## **Development Facilitation Team (DFT) – Review Comments**

**Project No: PR-2024-009929   Date: 05/08/2024   Agenda Item: #1   Zone Atlas Page: J-14**

**Request: Proposed Vacation of a portion of remaining public alleyway from the southeast of subject lots. Preliminary/Final Plat review of proposed minor subdivision to create one new lot from 3 existing lots. Request determinations from alleyway width adjoining lots and from landscape buffer along 3<sup>rd</sup> St Frontage given existing 6ft sidewalk and buildings at property lines.**

### **Application For: SD-2024-00073 – VACATION OF PUBLIC RIGHT-OF-WAY**

**Plat for
 Lot 19-A, Block 9, Homestead and
 Garden Spot Addition
 Being Comprised of
 Lots 19, 20 and 21, Block 9,
 Homestead and Garden Spot Addition;
 and vacated portion of alleyway
 City of Albuquerque
 Bernalillo County, New Mexico
 February 2024**

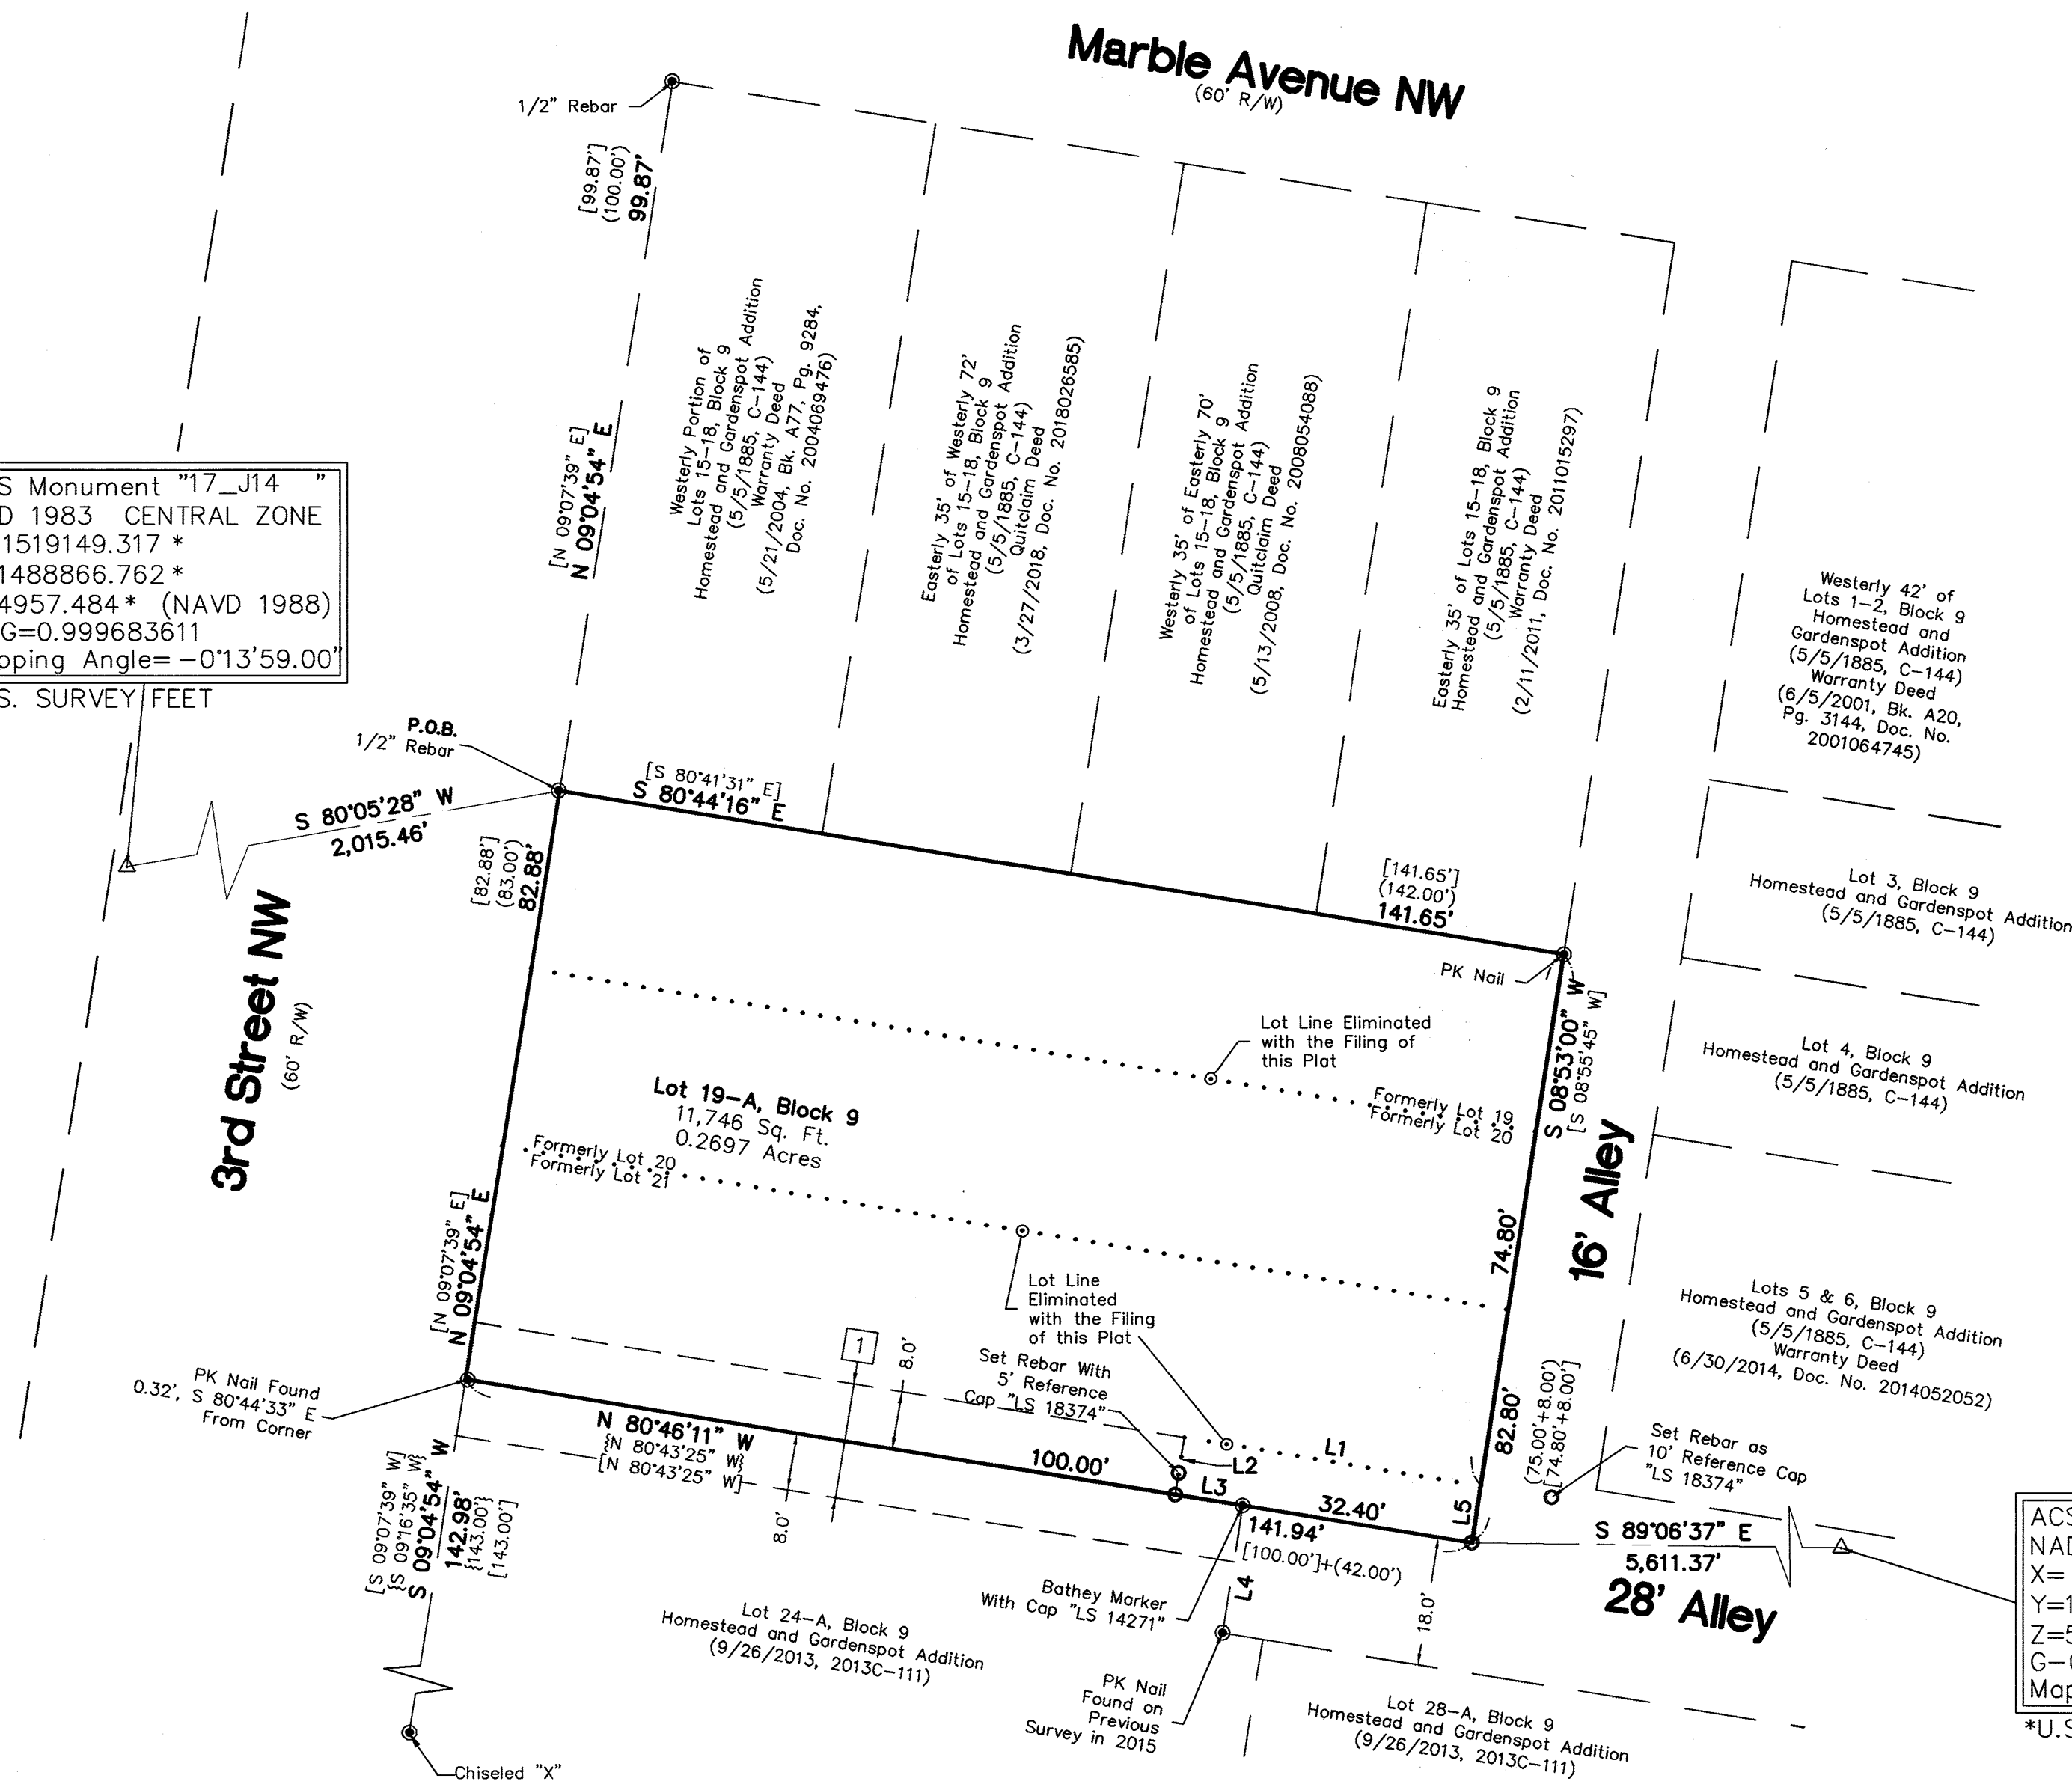
1. The plat does not indicate any vacation. Please clarify.

- The existing configuration of a hammerhead at the end of the alley provides a turnaround mechanism. An existing building is now encroaching in the public ROW (area hatched in black below).  
*\*Planning defers to Transportation to determine if remainder of alley area is sufficient for turnaround of vehicles.*
